DEVELOPMENT REVIEW BOARD  
SUPPLEMENTAL SUBMITTAL

PROJECT NO. PR-2019-002277  
Application No. SI-2019-00246

SUBMITTAL DESCRIPTION: DRB Site Plan Resubmittal.

RE: Adagio Apartments  
PR-2019-002277

PROJECT NAME: ADAGIO APARTMENTS  
SHEET TITLE: SITE PLAN  
DRB SITE PLAN  
SHEET NUMBER: C-100

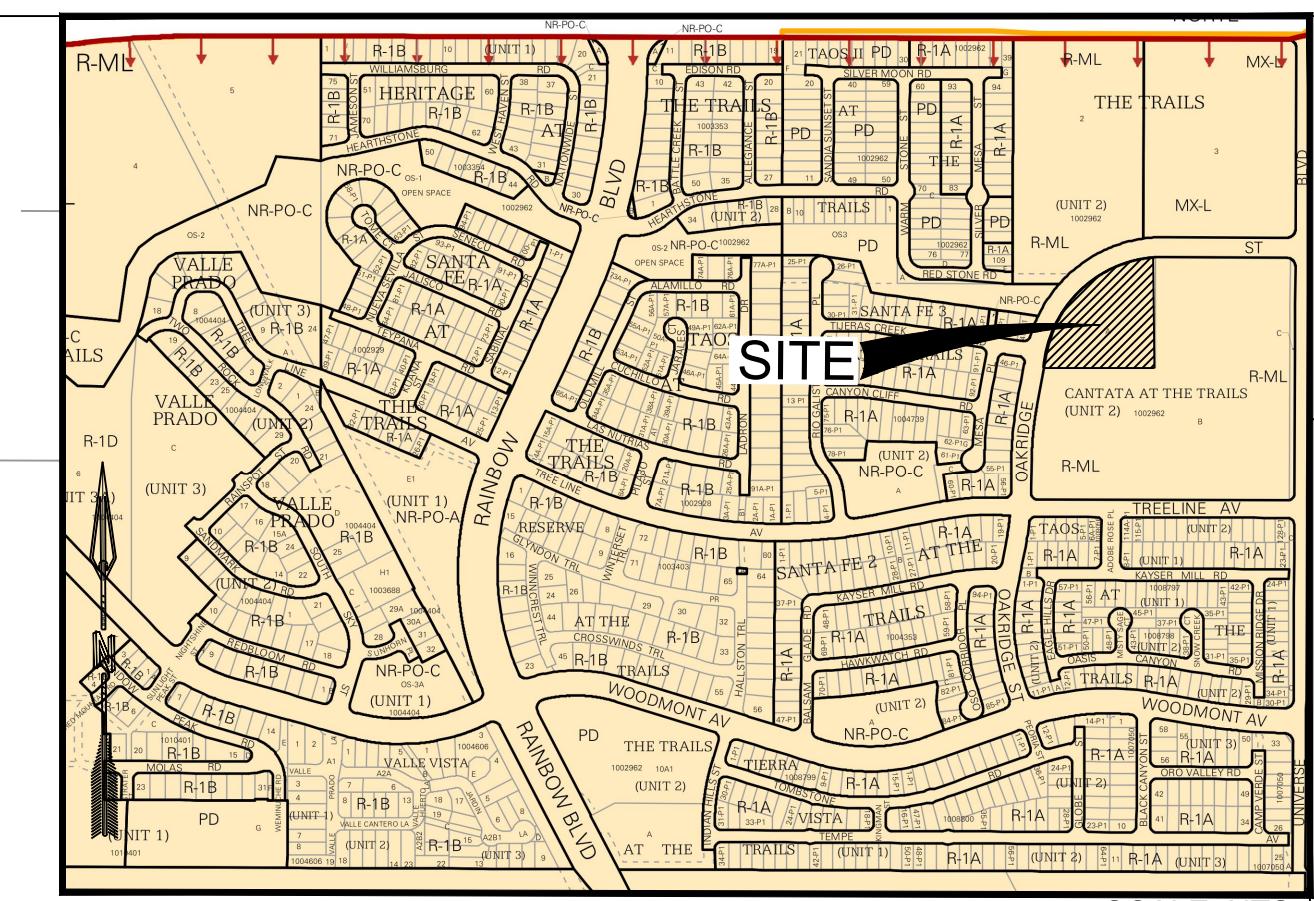
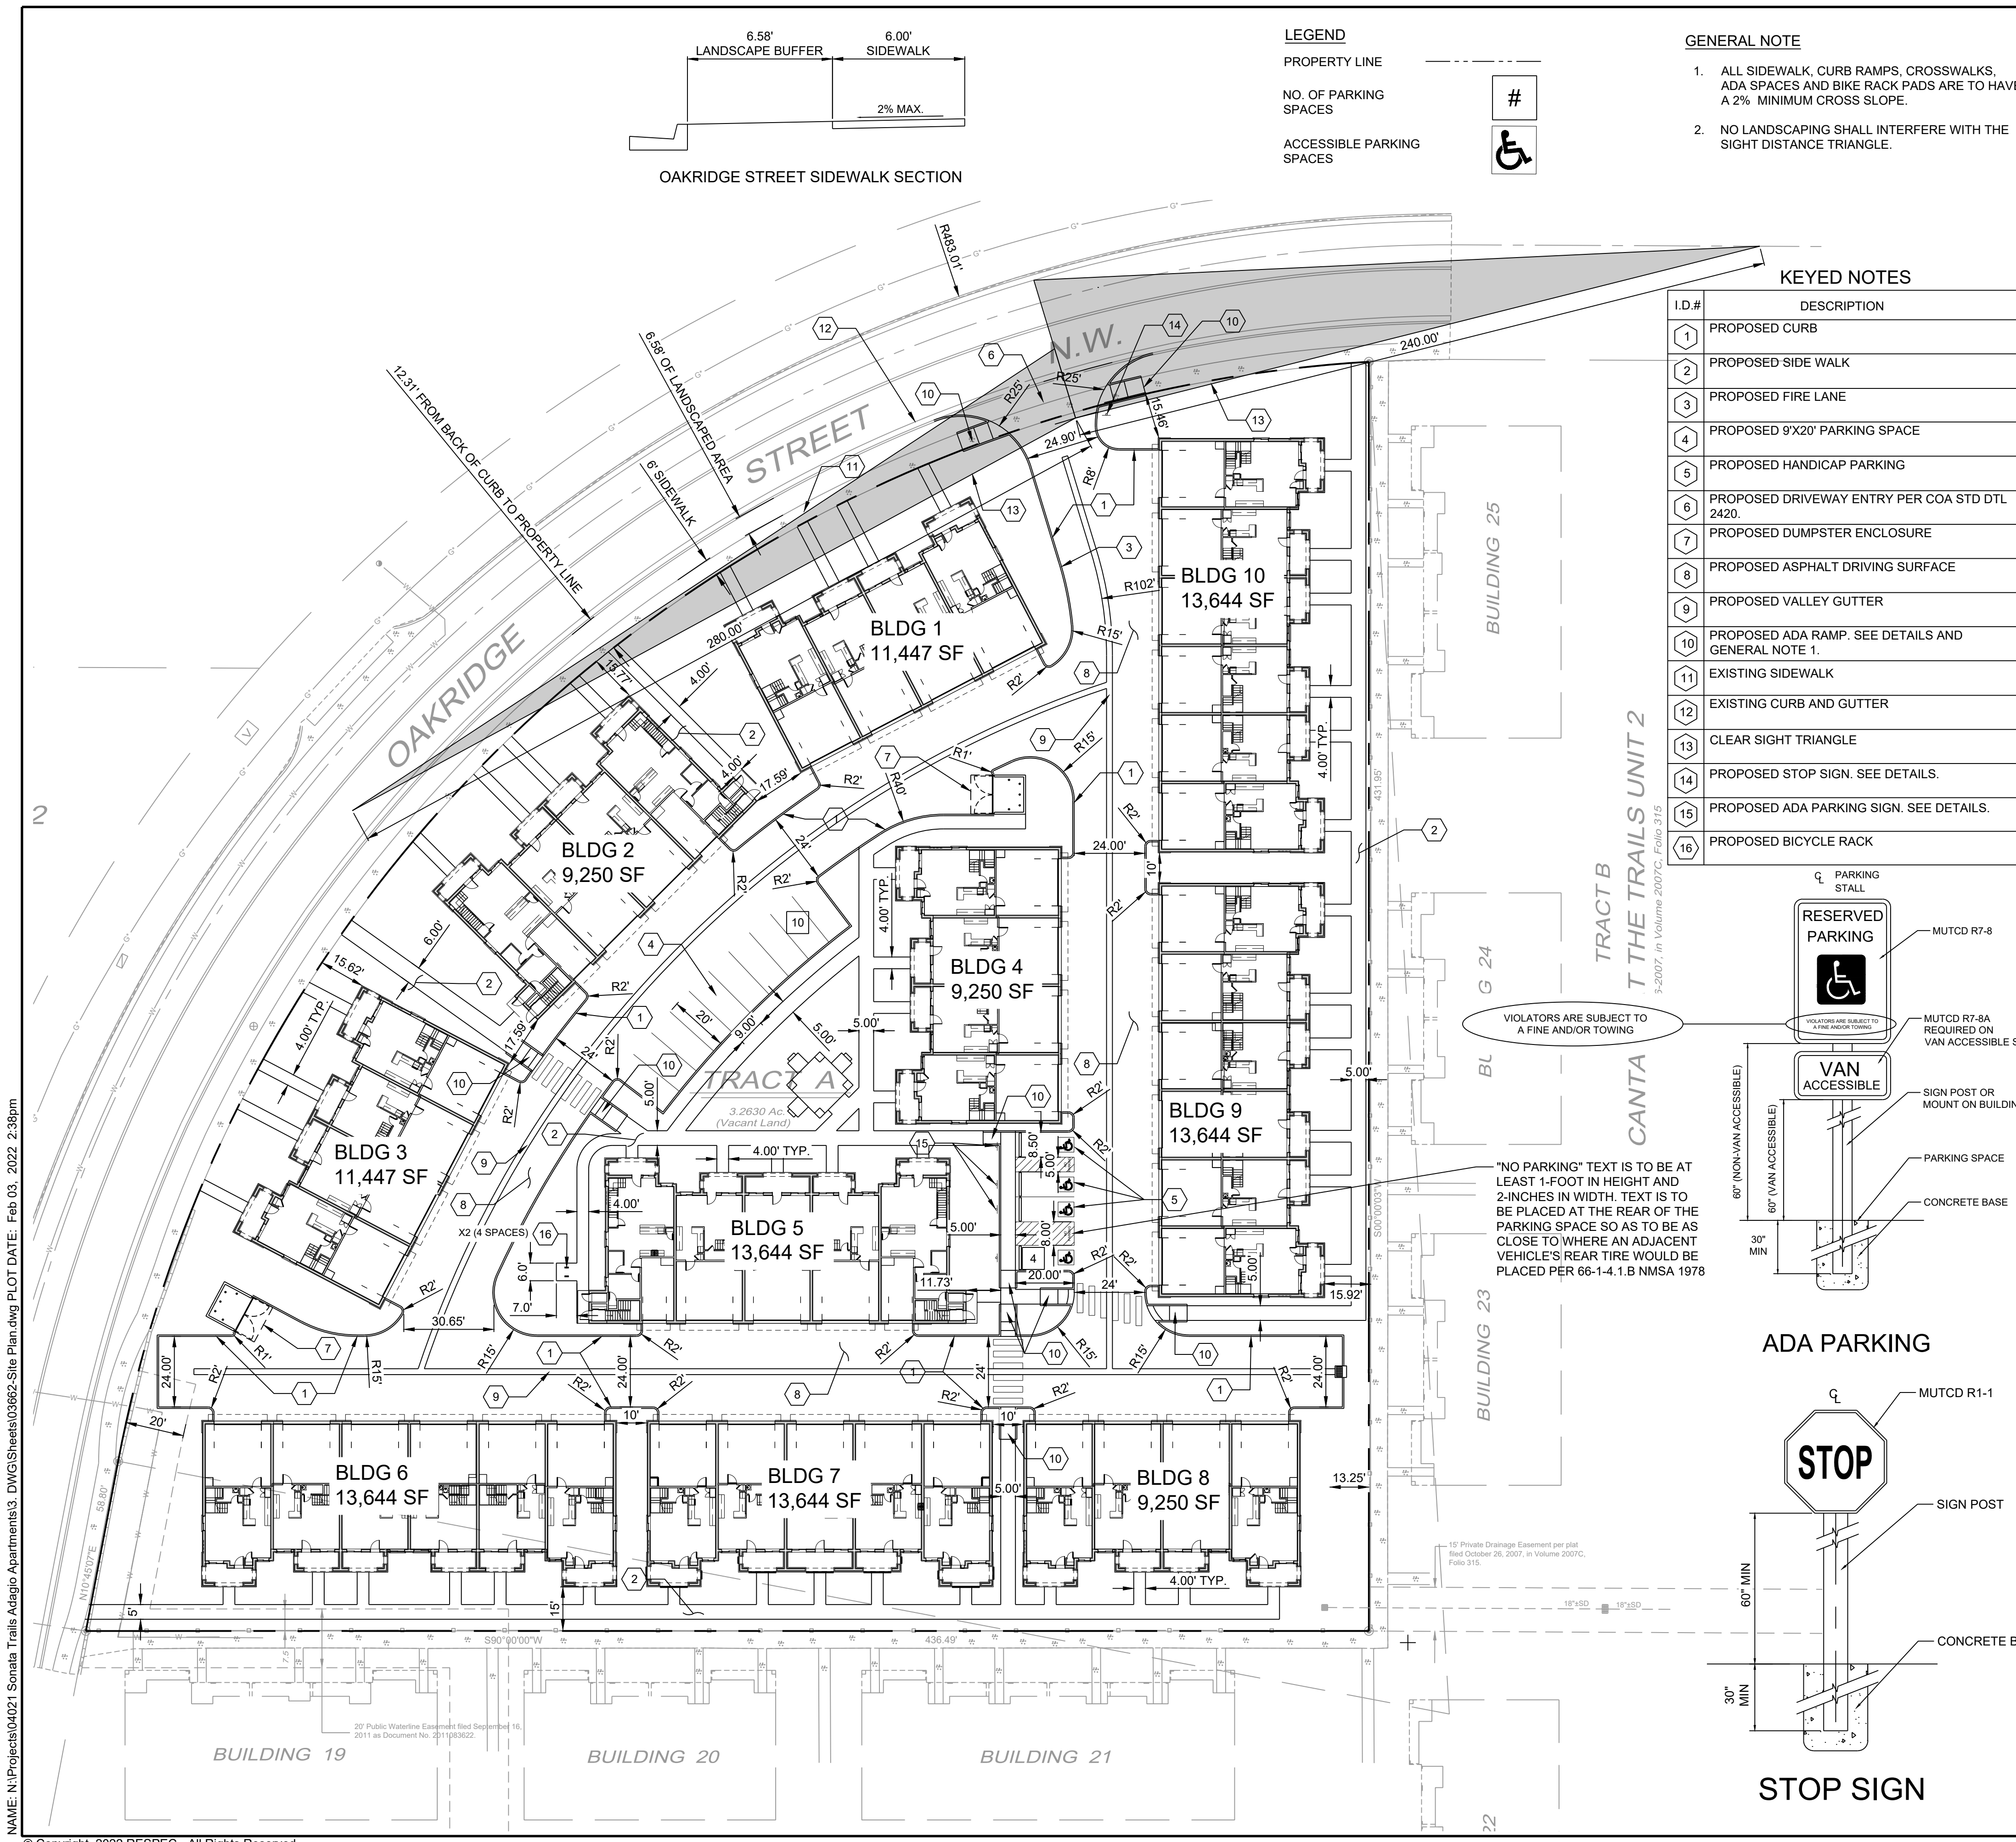
- / List number of multi-housing units on plan.
  - o *Response: Multi-housing units have been listed under Site Data on the revised Site Plan attached.*

- / Provide more detail at the entrance with regard to ADA accessibility, and provide civil details showing with additional curb ramp details as needed, sidewalk details showing 2% maximum sidewalk cross-slopes, crosswalks, handicapped parking spot details, bike rack details, etc. (Follow IDO/DPM guidelines on needed bike rack details.) (Use COA standard detail references for the entrance.)
  - o *Response: Keyed note 6 has been updated to reference COA standard detail 2420. See revised Site Plan attached.*

- / Keyed notes are needed for curb ramps at the van accessible aisles and at the end of each crosswalk. Also indicate bicycle rack locations.
  - o *Response: Keyed notes have been added for curb ramps at the van accessible aisles. Proposed bike rack location is also included. See revised Site Plan attached.*

- / Label width of all sidewalks on the plan.
  - o *Response: Sidewalk widths have been labeled throughout on the revised Site Plan attached.*

- / The ADA accessible parking sign detail shows "Violators Are Subject to a Fine and/or Towing." (This wording should be more visible on the plan.)
  - o *Response: The revised Site Plan attached has been updated to make this text more visible.*

- / The ADA access aisles shall have the words "**NO PARKING**" in capital letters, each of which shall be at least one foot high and at least two inches wide, placed at the rear of the parking space so as to be close to where an adjacent vehicle's rear tire would be placed. (66-1-4.1.B NMSA 1978). This should be clearly called out on a note or a detail.
  - o *Response: A note has been added to the revised Site Plan attached.*

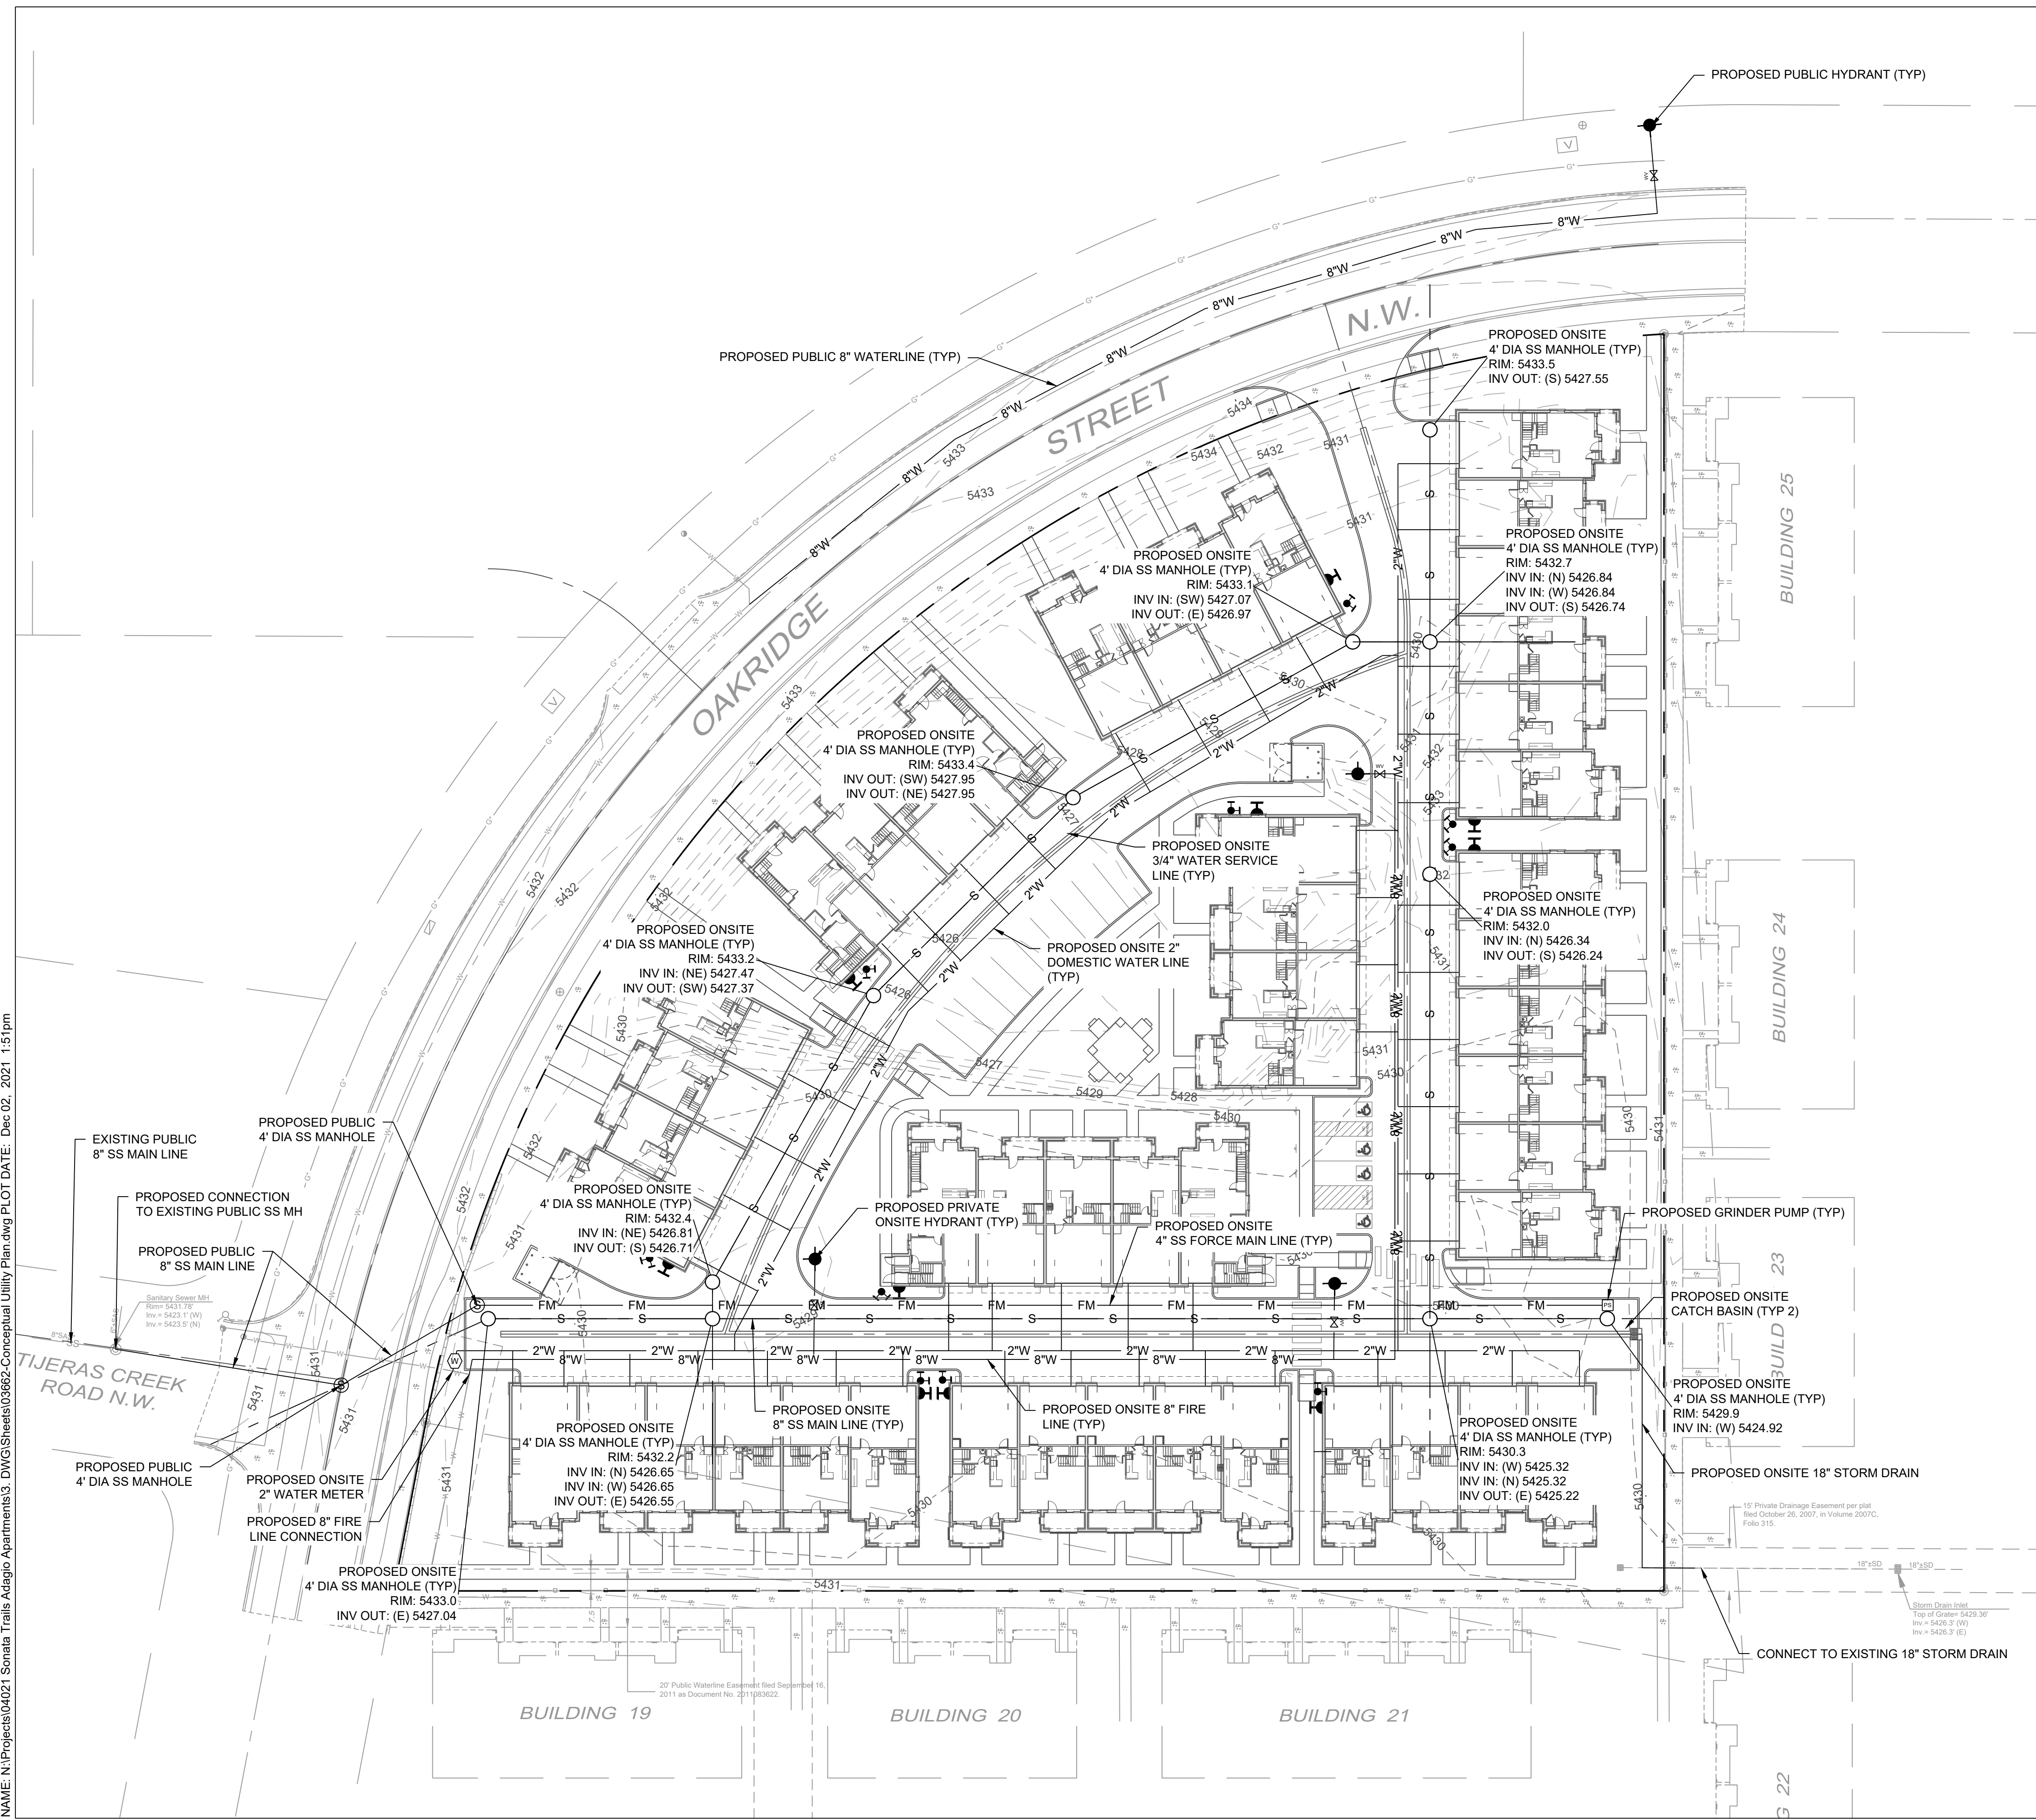
- / Utility Plan
  - If the 2-inch water meter does not provide sufficient flows, a larger meter, meter vault, and easement may be required. Please confirm sizing of the proposed meter.
    - *Response: Conceptual calculations have been completed and a 2-inch water meter will be sufficient to provide service to this development.*
  - Please label the 8-inch fire line connection.
    - *Response: The 8-inch fire line connection has been labeled. See revised Conceptual Utility Plan attached.*
  - Clearly delineate the existing versus proposed 8-inch sewer main.
    - *Response: Labeling for the existing and proposed sewer has been updated to clearly delineate between the two. See revised Conceptual Utility Plan attached.*
